From: Thomas Callaway
Sent: 22 July 2015 16:42
To: Simon Davis
Subject: RE: Westergate Phase 2 - AL/46/15/DOC

The details are okay to discharge the surface water drainage condition

You previously advised that you could not approve condition 12 of AL/114/12. I have now received the attached information which should resolve your earlier concerns?

Project No.	Scale	Drawing No.	Sheet No.	Revision
FA E-F1613.00	1:200	300	1 of 1	P2

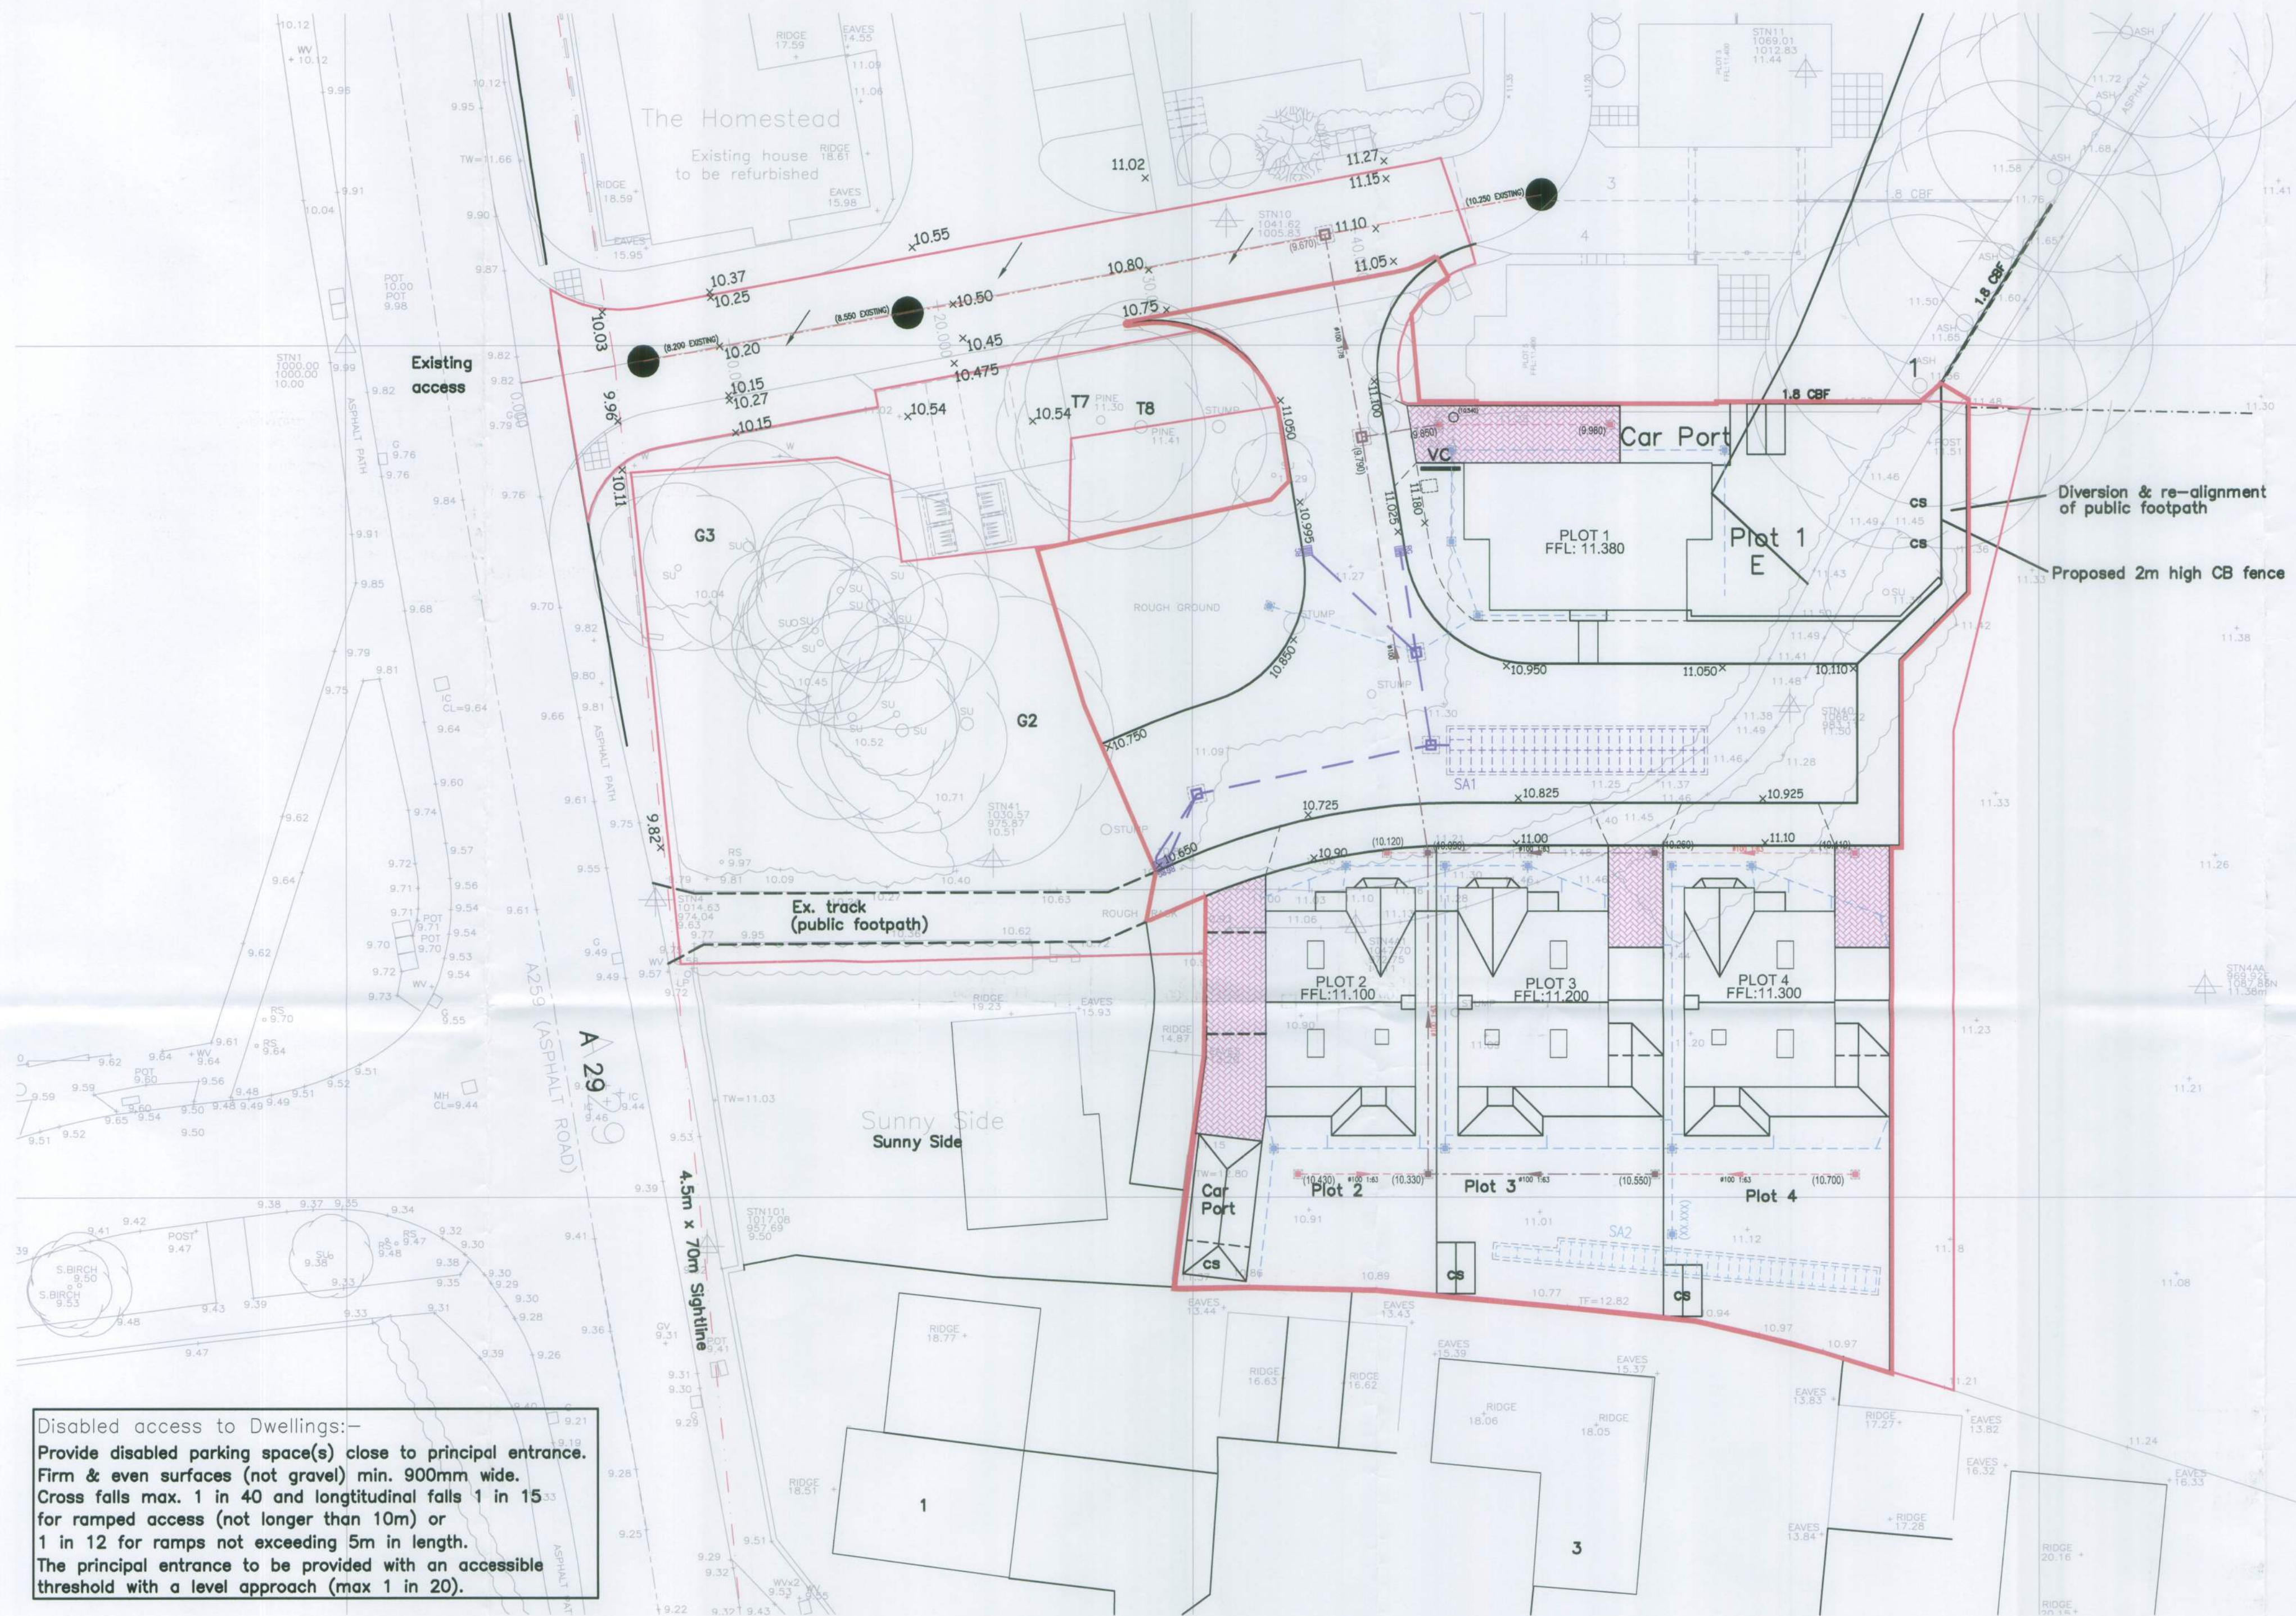
As regards the soakaway design in relation to ground water levels, both soakaways are 800 deep below the soffit level given on the drawing. This puts the bottom of the soakaways at a level of 9.36m -- equal to the highest recorded ground water level. If needs be, we can raise the soakaways marginally, but we are already quite close to the minimum 600mm depth of cover required for the aquacell units.
